**Re Northside Clinic Development, 10 Herbert Street, Artarmon
Department of Planning & Environment Response**

Department of Planning & Environment (DoP&E) Reference: SSD 7588

Please find below our response for your review to the DoP&E, Northside Mental Health Facility Response to Submission letter dated September 6 2016. This letter report responds to the submission from Willoughby City Council and specifically to discussion point 6 of that document.

Discussion/Response 6. Stormwater (Drainage)

ON-SITE DETENTION SECTION A
SCALE 1:20

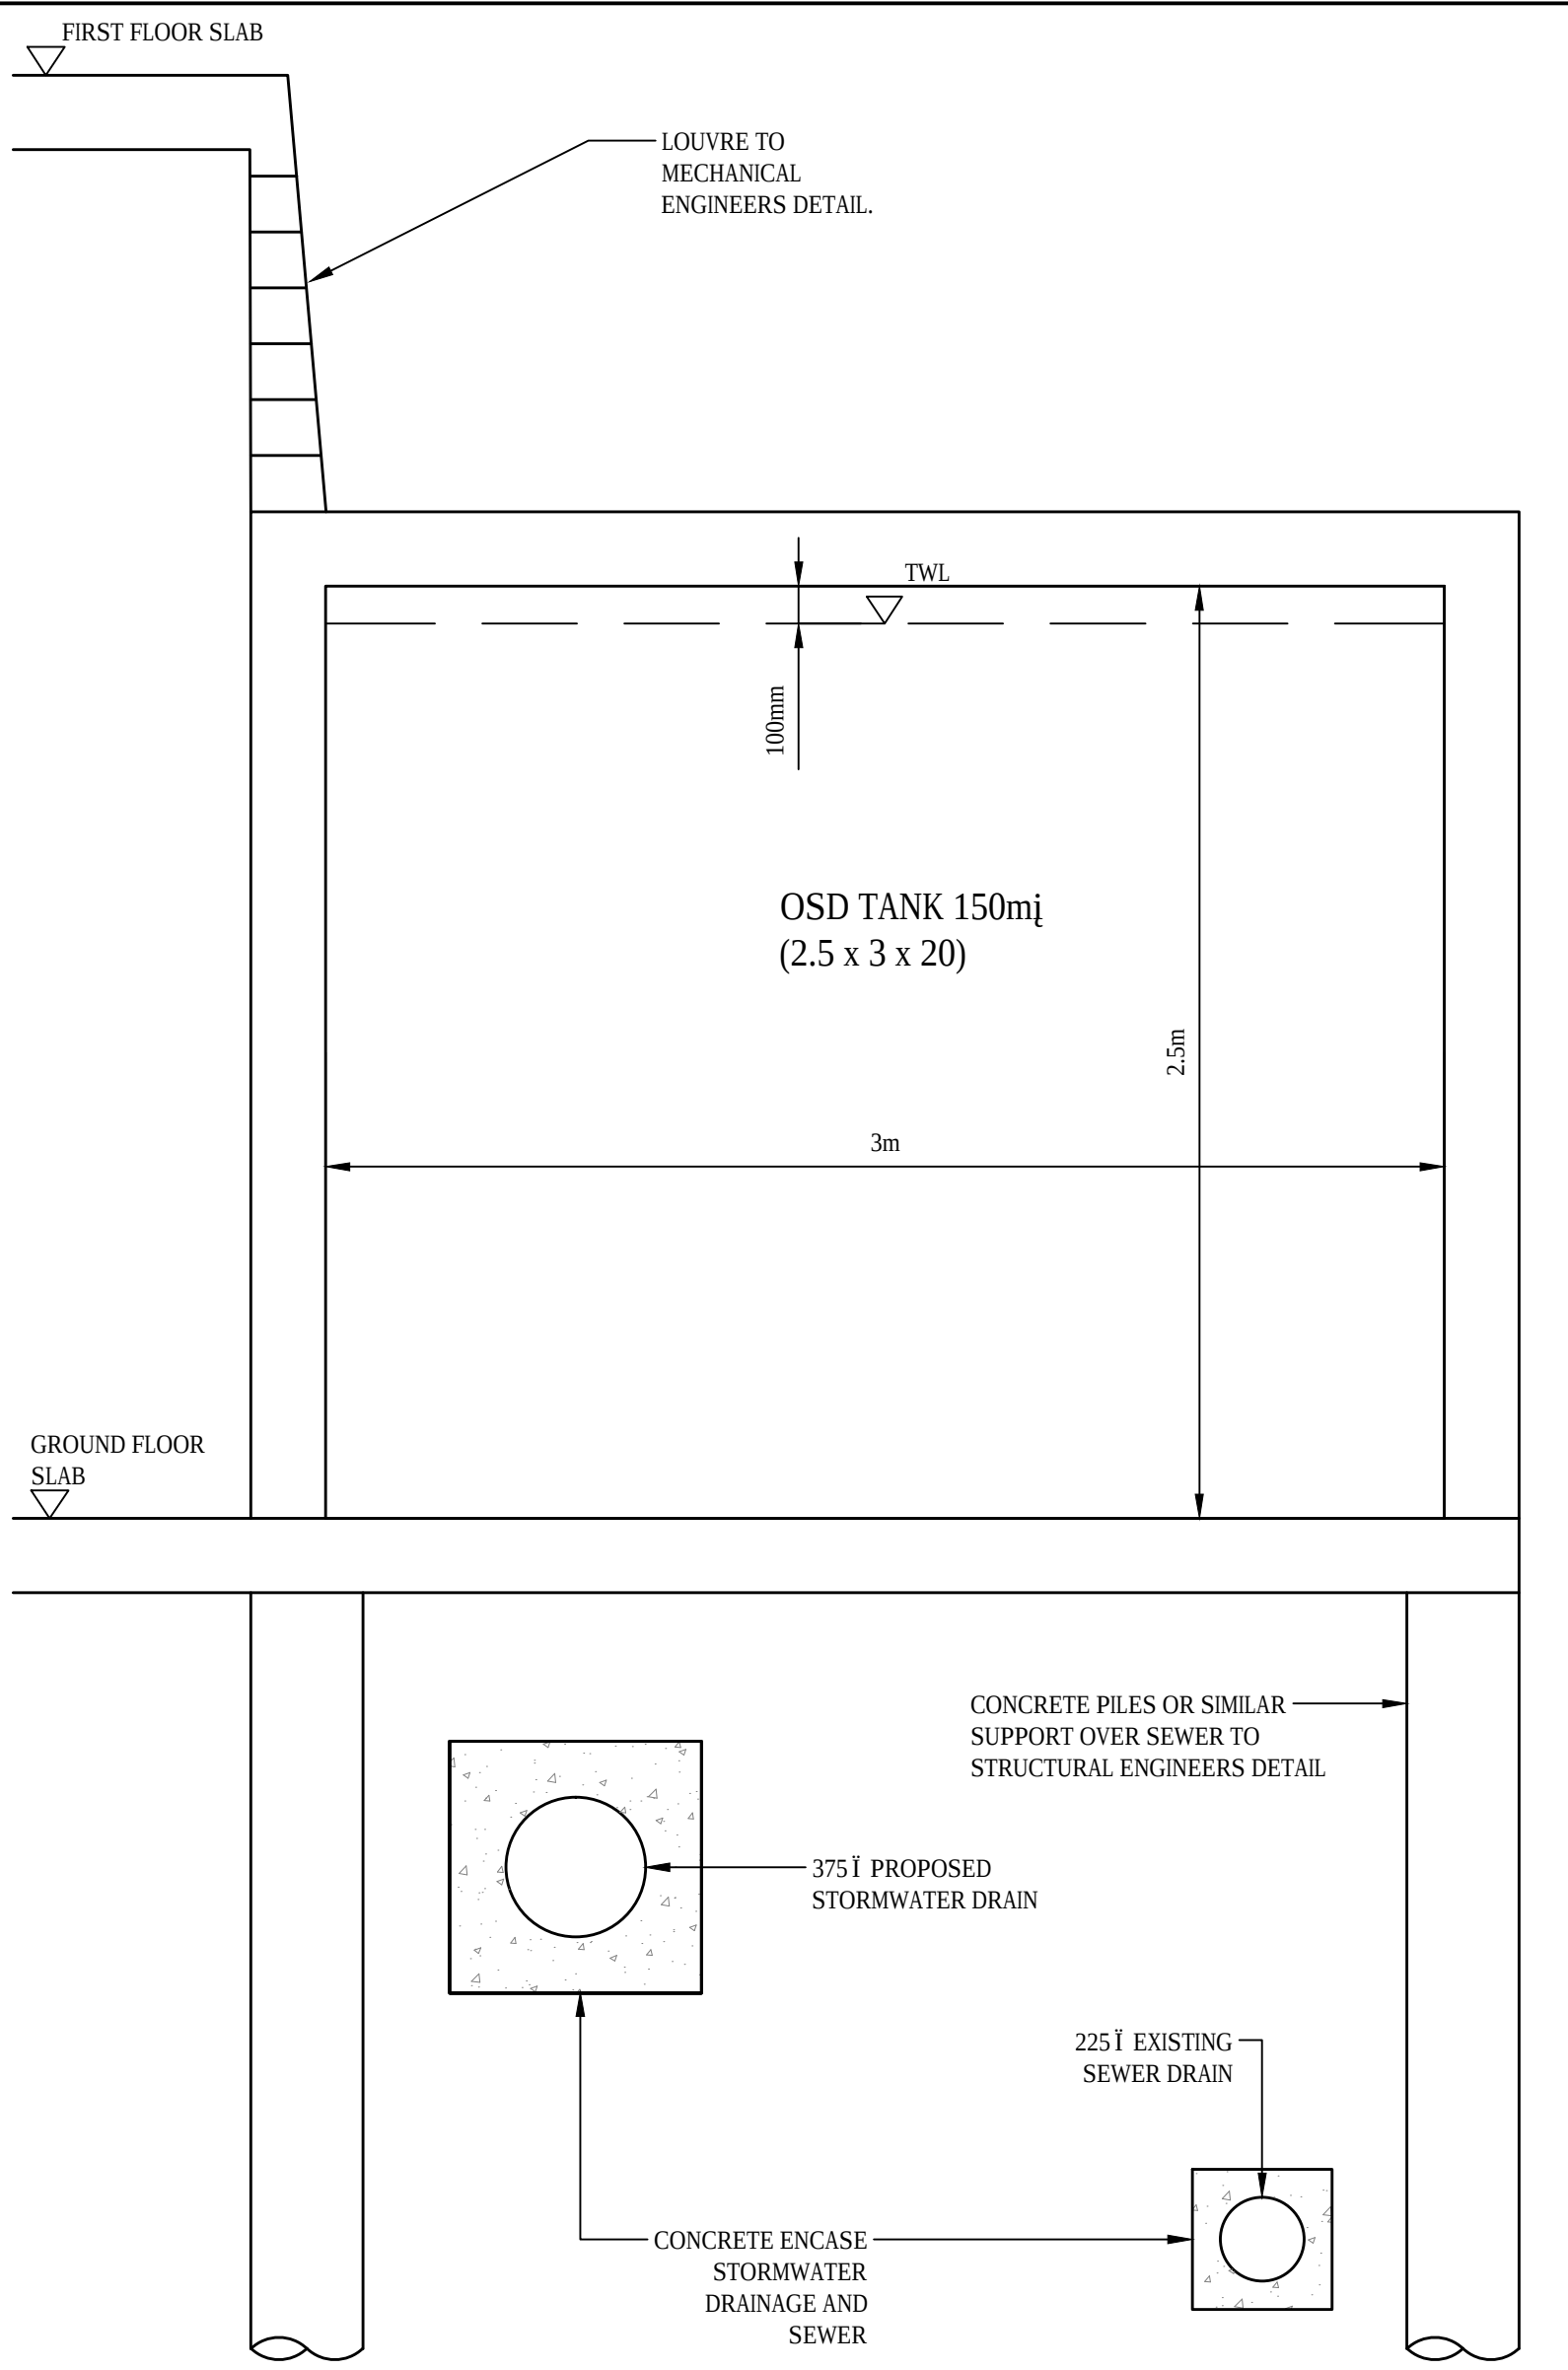
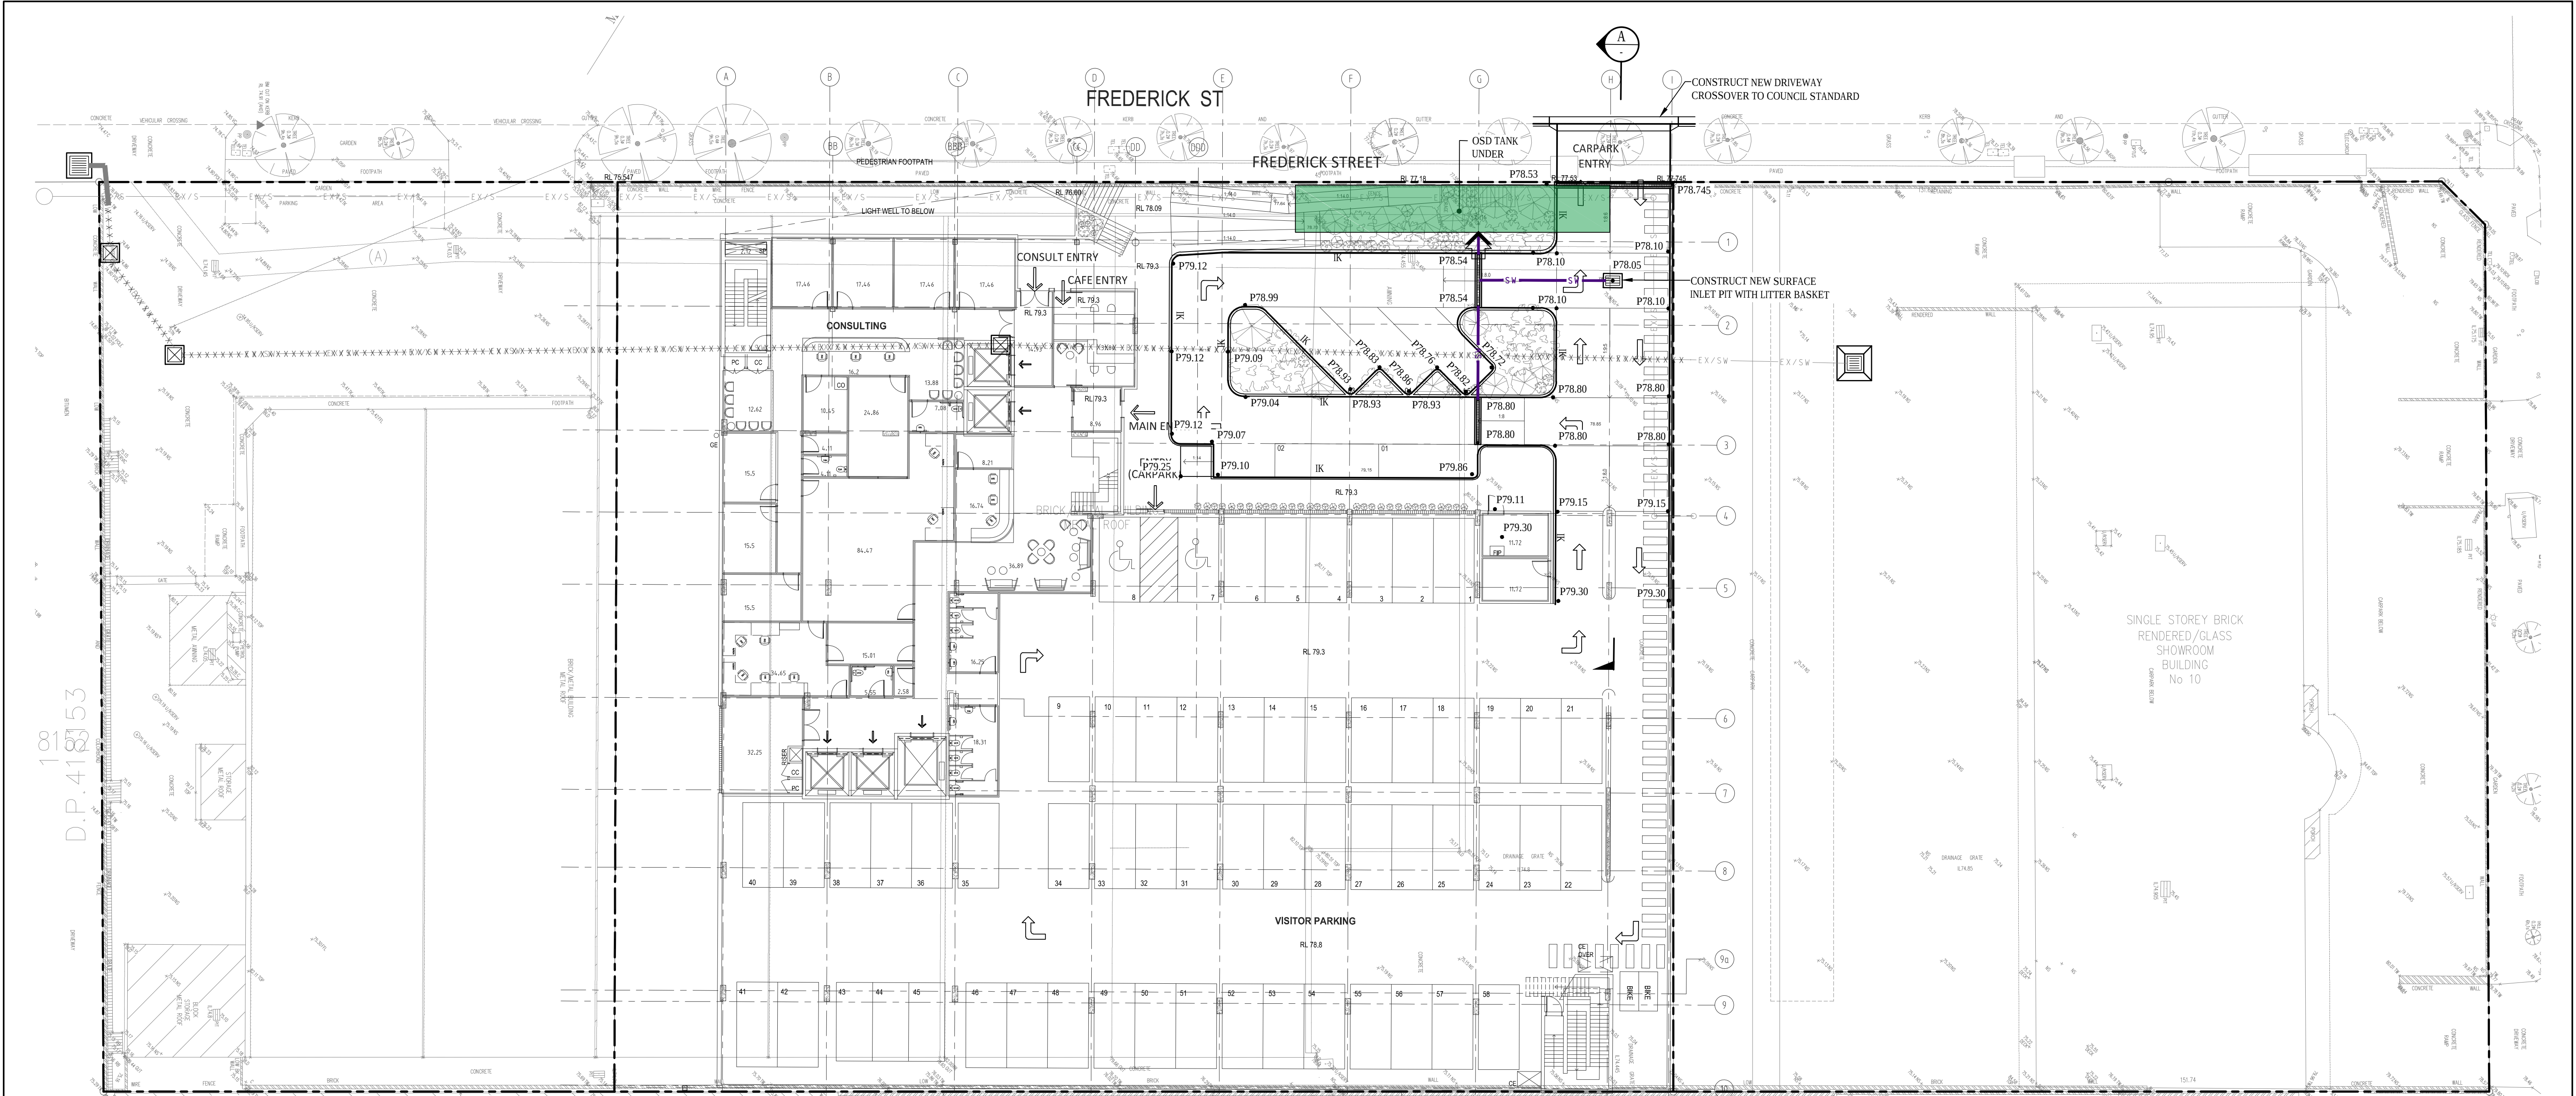
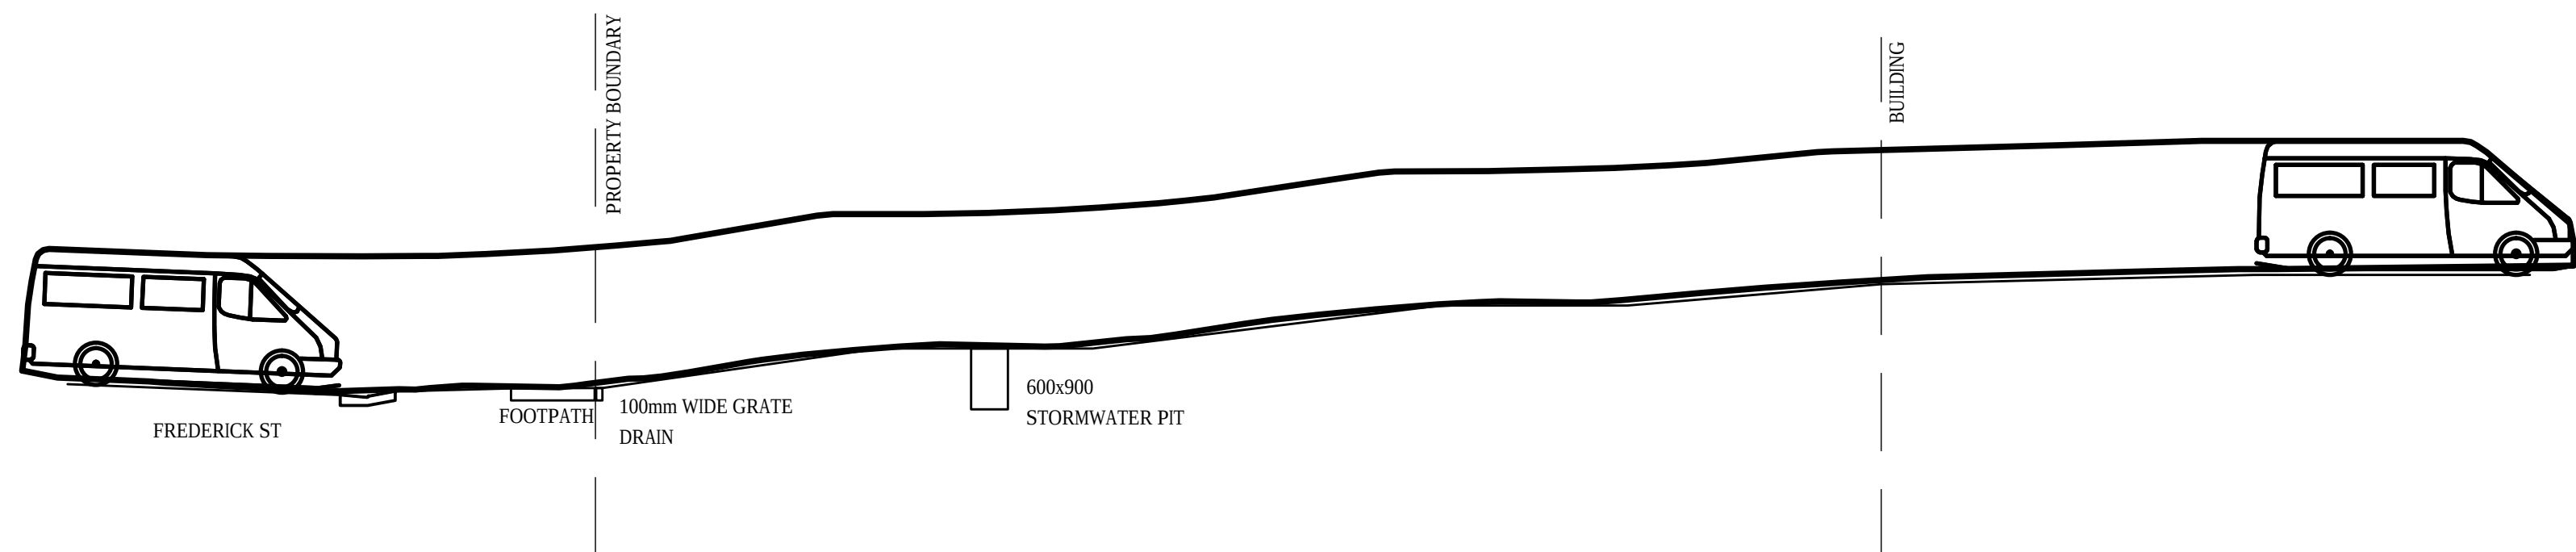
The stormwater management plans submitted with the SSD are considered inadequate and inaccurate in their current form. The stormwater drainage management plan should be redesigned in order to allow the overflow of the proposed on site detention system to be discharged to Frederick Street without causing any extra runoff to the downstream properties, as there is no underground pipe system fronting the proposed development.

The stormwater drainage management plan submitted for the development site, allows for all stormwater drainage from the site to be directed through an on site detention (OSD) system before discharging to the Council stormwater drainage network. This meets Councils requirements as specified in the Willoughby Development Control Plan (WDCP) Attachment 24 - Stormwater Design Elements and Attachment 25 On-Site Detention.

The OSD has been designed to discharge to the existing interallotment stormwater pipe that traverses the site to the benefit of the property upstream. A separate DA application has been made to Council, as stated above, to divert this existing pipe to suit the proposed development footprint.

The design intent is to upgrade the existing interallotment stormwater drainage as part of these works to allow the OSD to connect to this system without exceeding the capacity of the network. Any overflow from the OSD tank discharges to the kerb in Frederick Street as per Council requirements.

A Hydraulic Grade Line analysis and OSD design has subsequently been completed since the initial application and confirms that there will be no additional runoff from the site to either Councils stormwater drainage or to downstream properties as a result of the development.
